Our Ref: AL/81/17/HH
Your Ref:

Town & Country Planning Act 1990 (as amended)
Town & country Planning (Development Management Procedure) (England) Order 2015
Application for Planning Permission for Works or Extension to a Dwelling

Development Erection of single storey outbuilding to rear garden
Location Mildmay Hook Lane Aldingbourne

SITE LOCATION & BLOCK PLAN

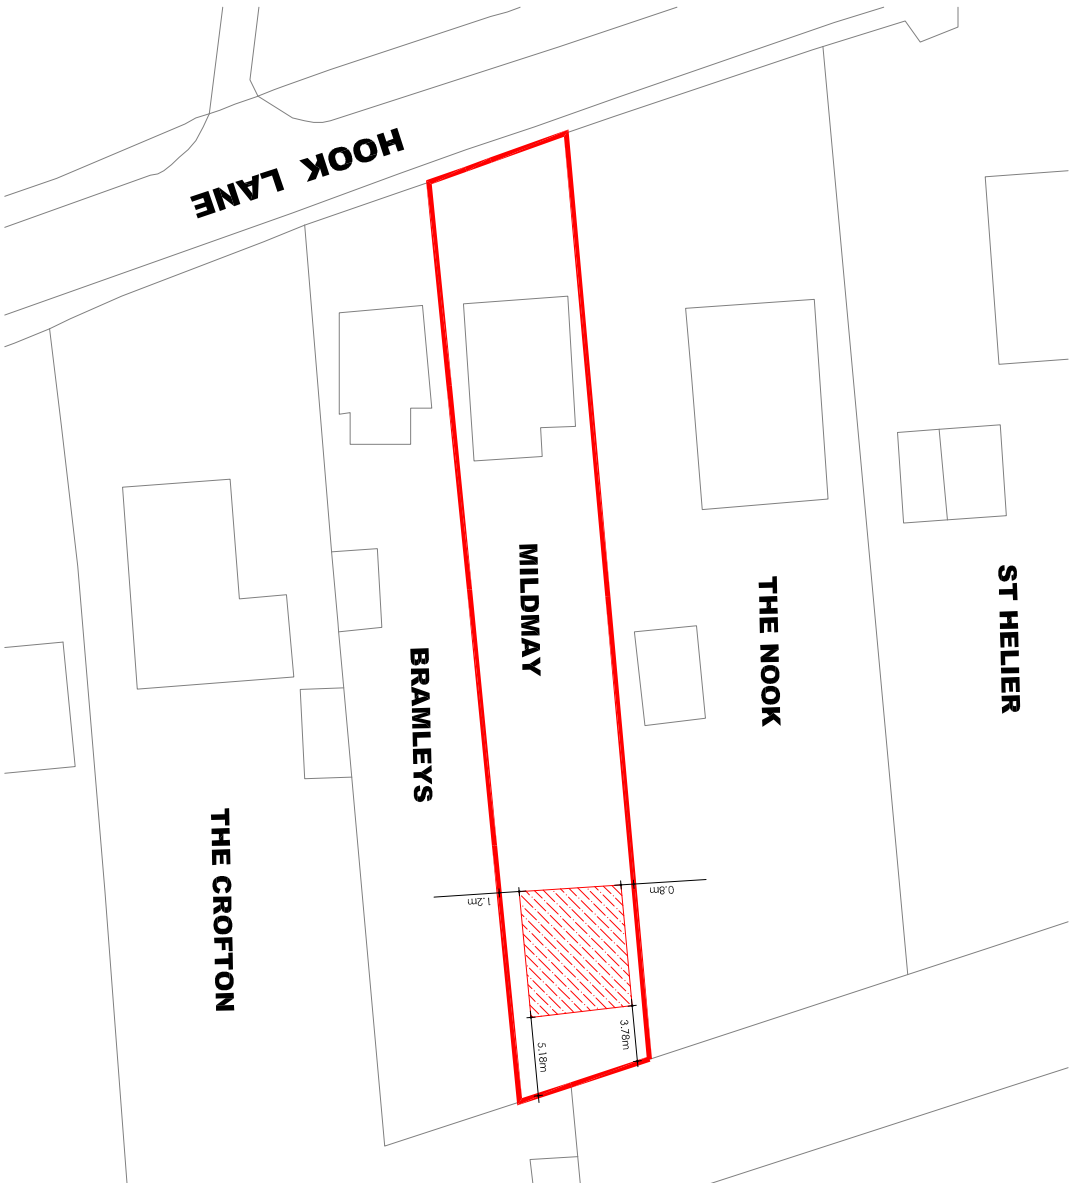
Location Plan - Amend

Please submit 1 electronic or 3 paper copies of an amended location plan at a scale of 1:1250 or 1:2500 for rural areas to include to road names or an arrow leading to a 2nd road name if too far away. Further details of what must be included on the plan can be found in the National Validation Requirements.

Block Plan - Amend

Please submit 1 electronic or 3 paper copies of an amended block/site plan at a scale of 1:500 or 1:200 to include the dimensions shown from the proposal to the boundary. Further details of what must be included on the plan can be found in the National Validation Requirements.

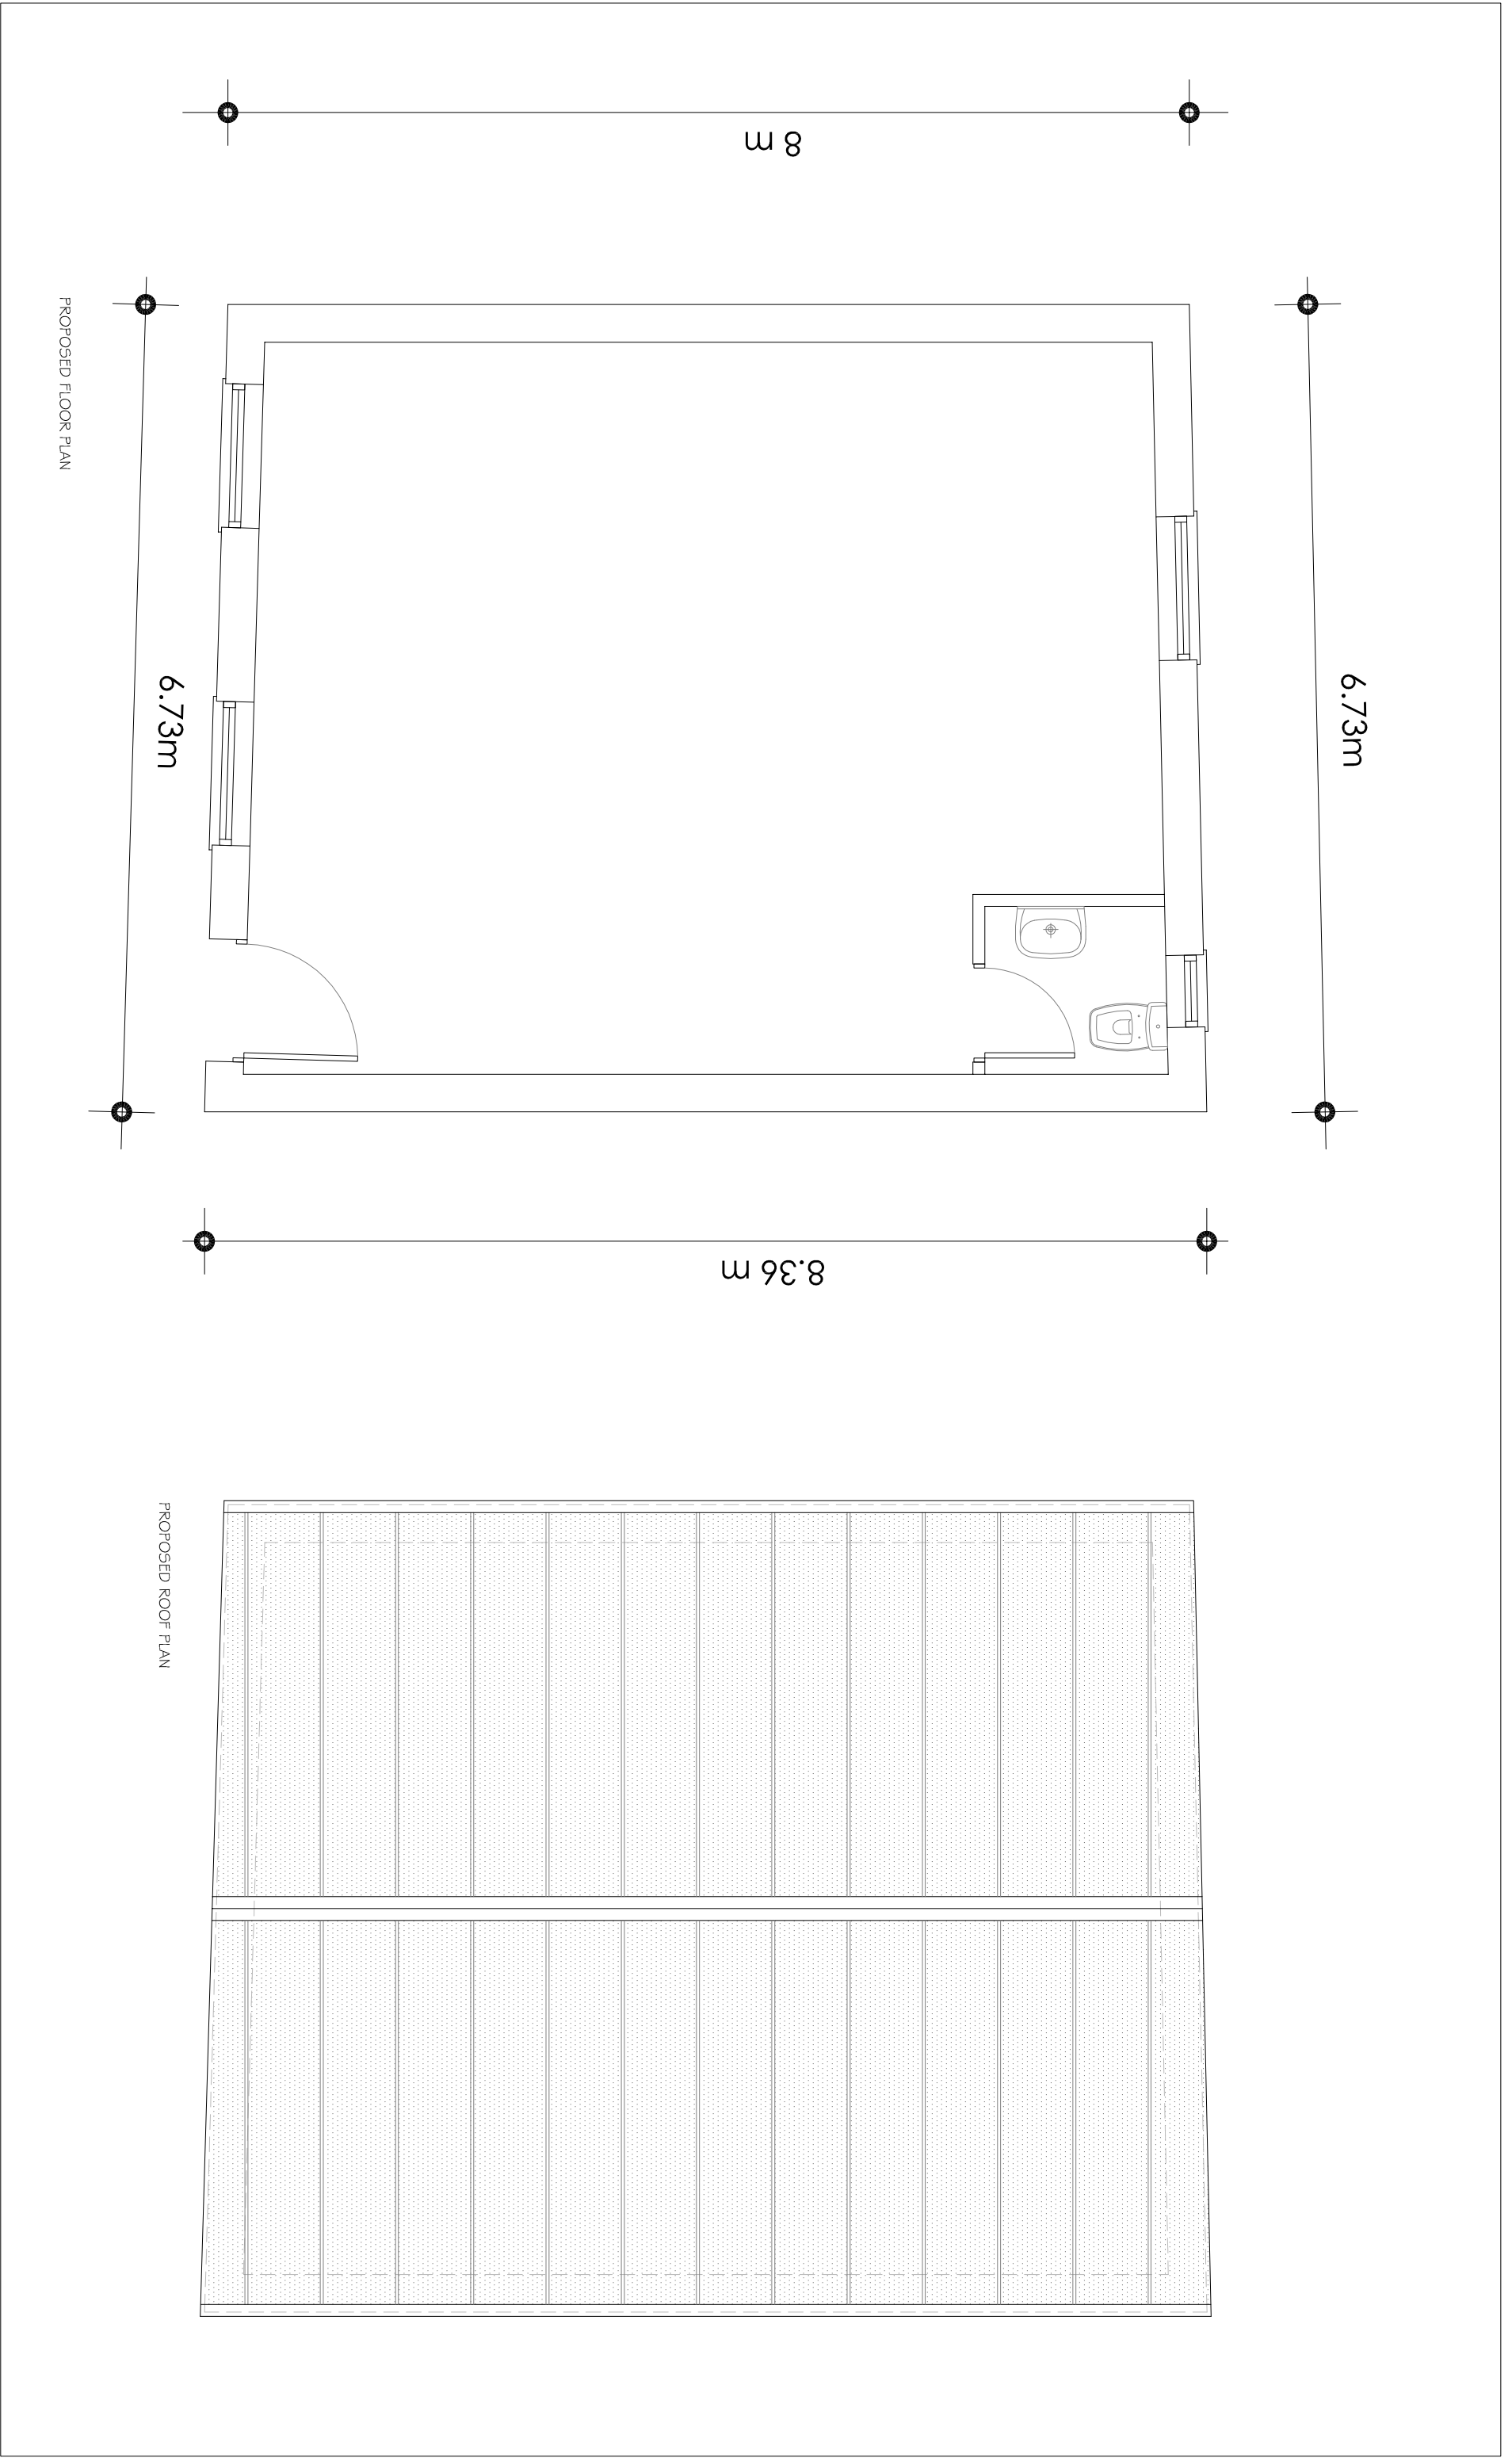
Roof Plan

Please submit 1 electronic or 3 paper copies of a roof plan of the proposed building. Please refer to the National Validation Requirements for further details.
